To: FILE
From: Nell Donaldson
Subject: Application ID: 2013-179
Date: 9/19/2013

To: Nell Donaldson
Barbara Barhydt
From: David Margolis-Pineo
Re: Review Comments – Bayhouse II – 40 Hancock Street

The Department of Public Services has the following preliminary review comments for the above mentioned project.

**TYPICAL DRAINAGE MANHOLE/CATCH BASIN**  
NOT TO SCALE

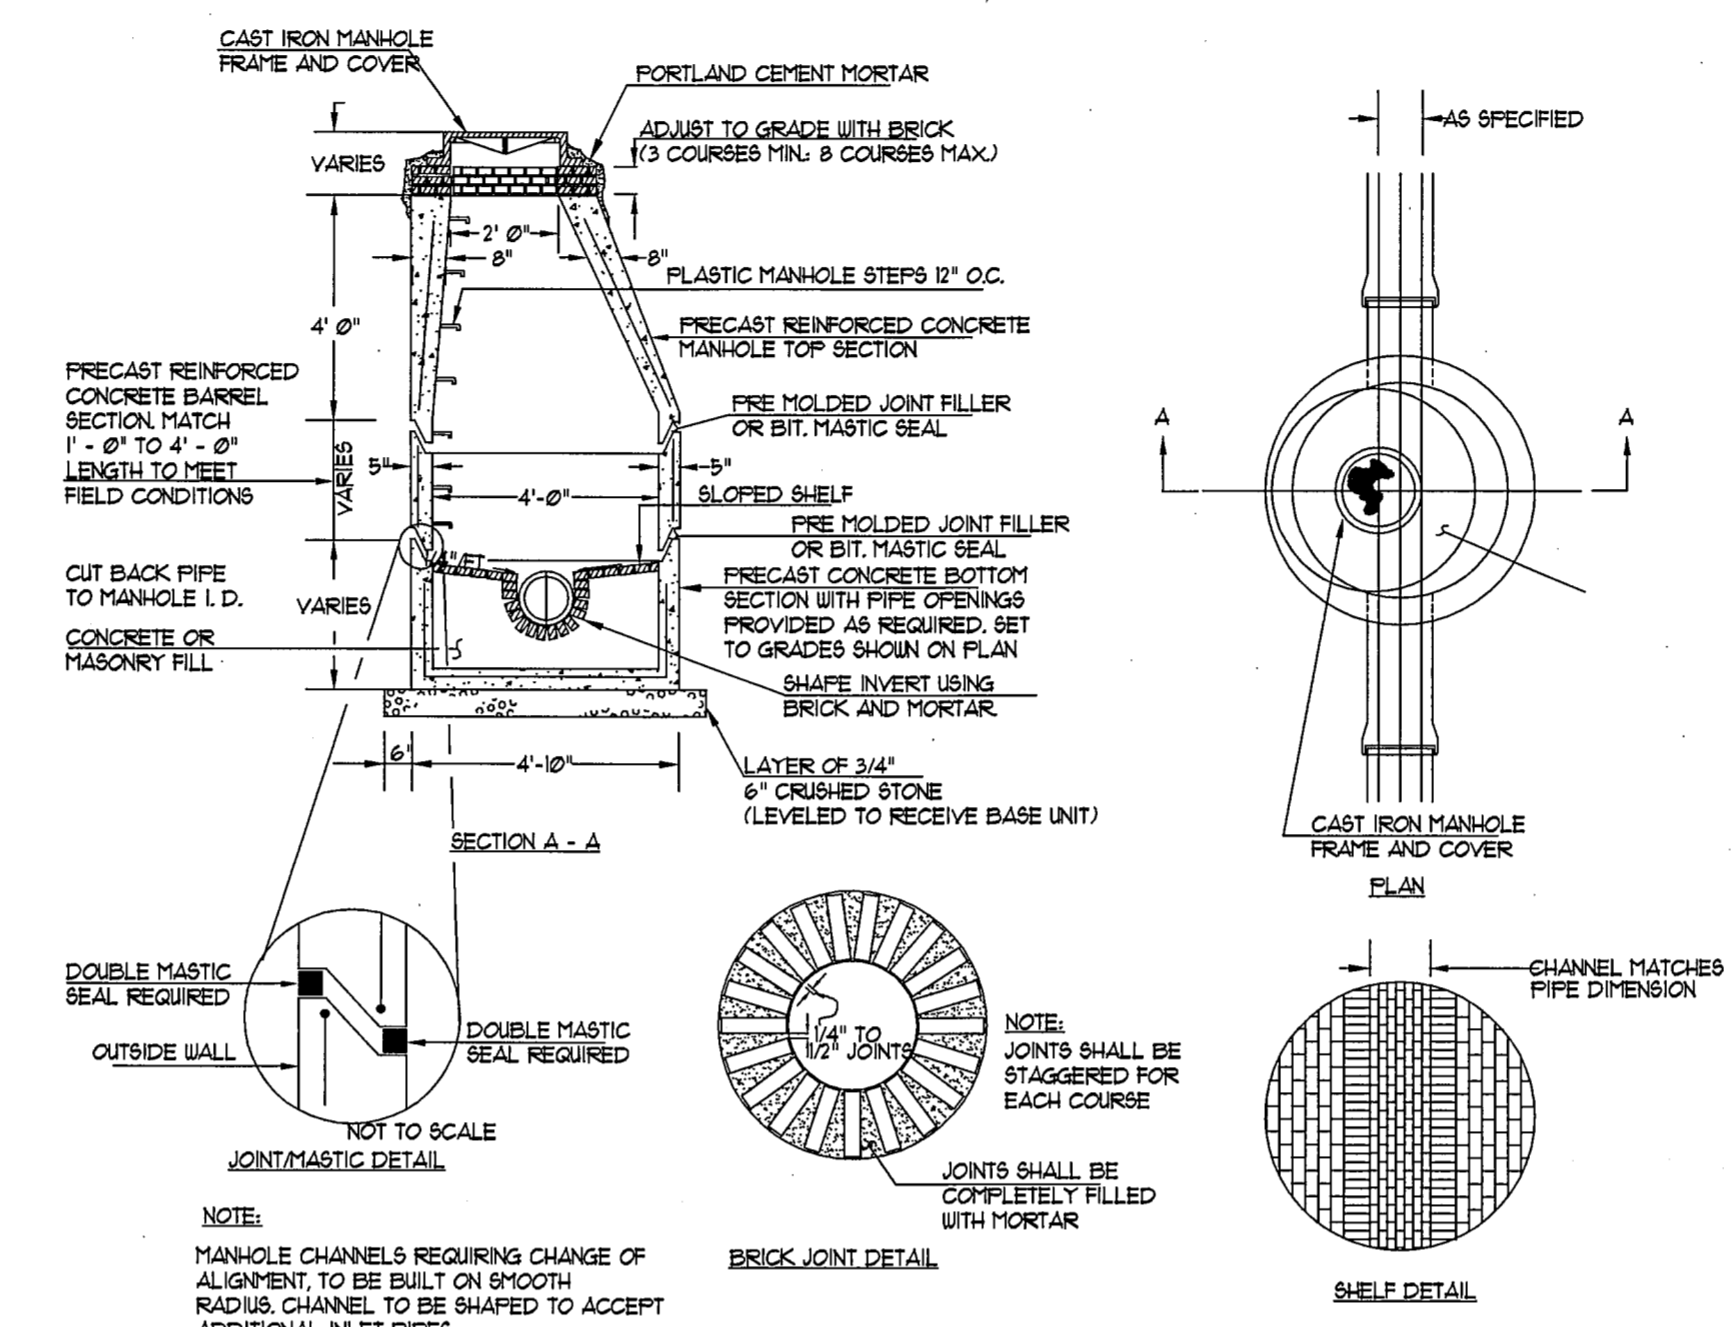
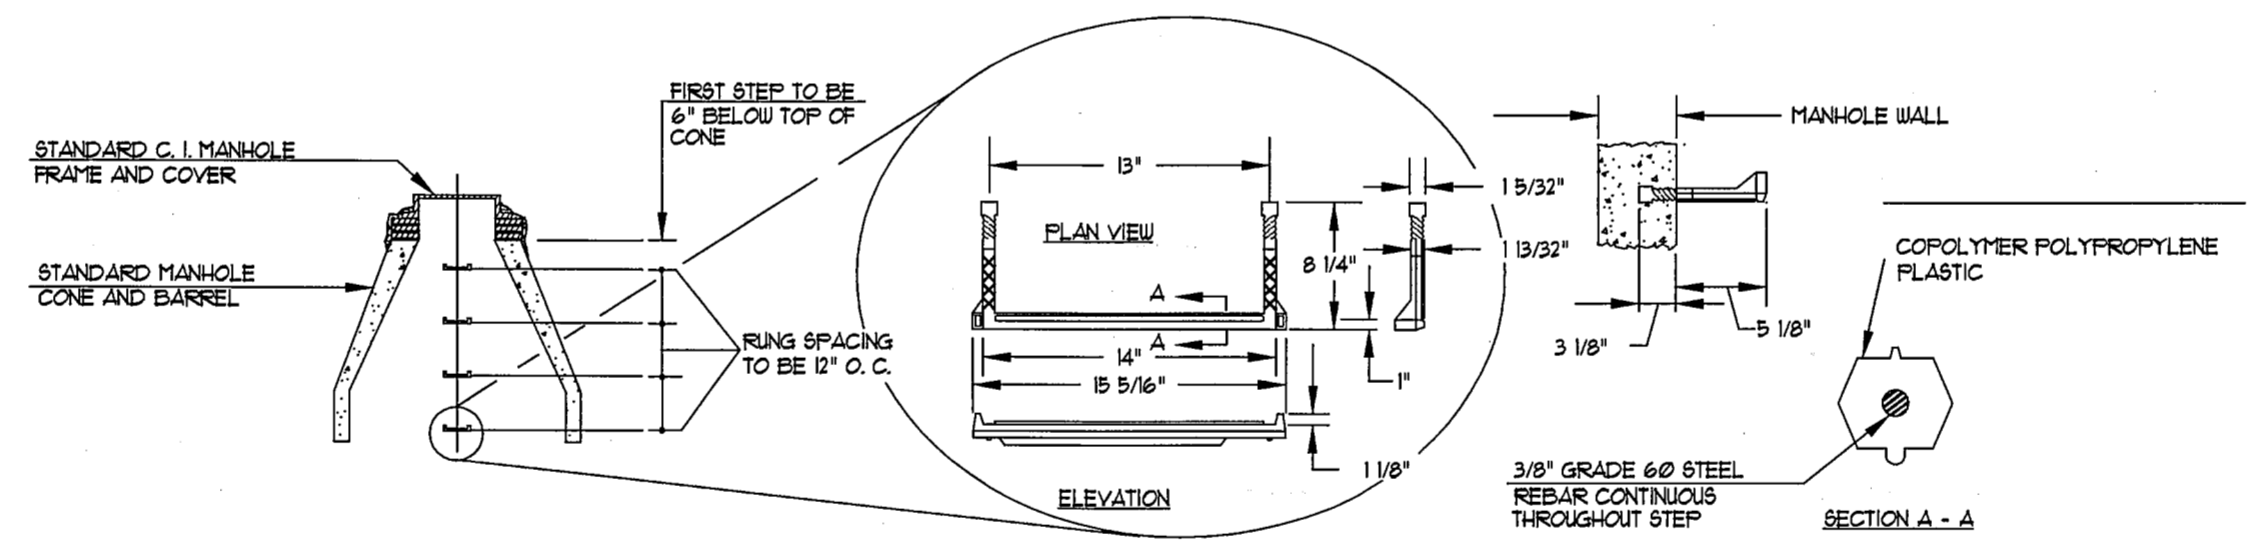
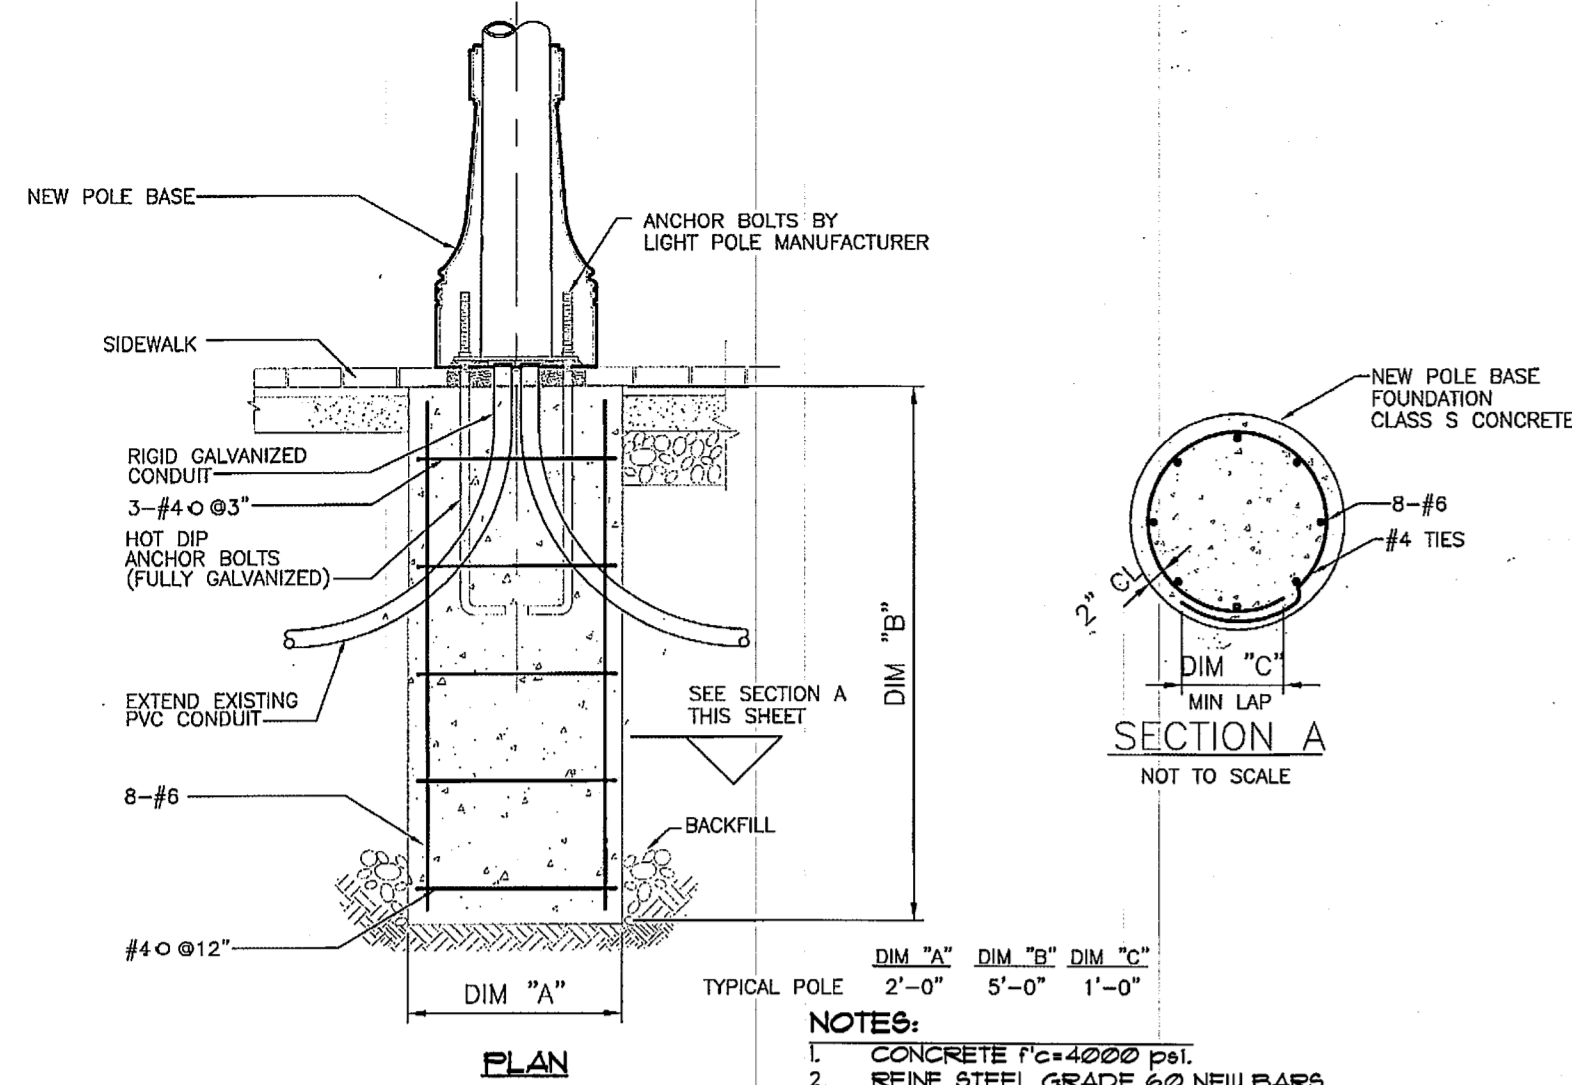
2. All catchbasins proposed for this project will have "The Snout" or approved equal install on the outlet pipe. Note on plans now indicates the use of the Snout. However the catchbasin detail does not show or indicate a three foot sump, the City's standard. It is understood that referencing the City's Tech Standards will address this. No further comment.
Note #5 on Sheet 12 of 14 should be changed to reflect that a three foot catchbasin sump is required. This should be done prior to the pre-construction conference and re-submittal is not required.
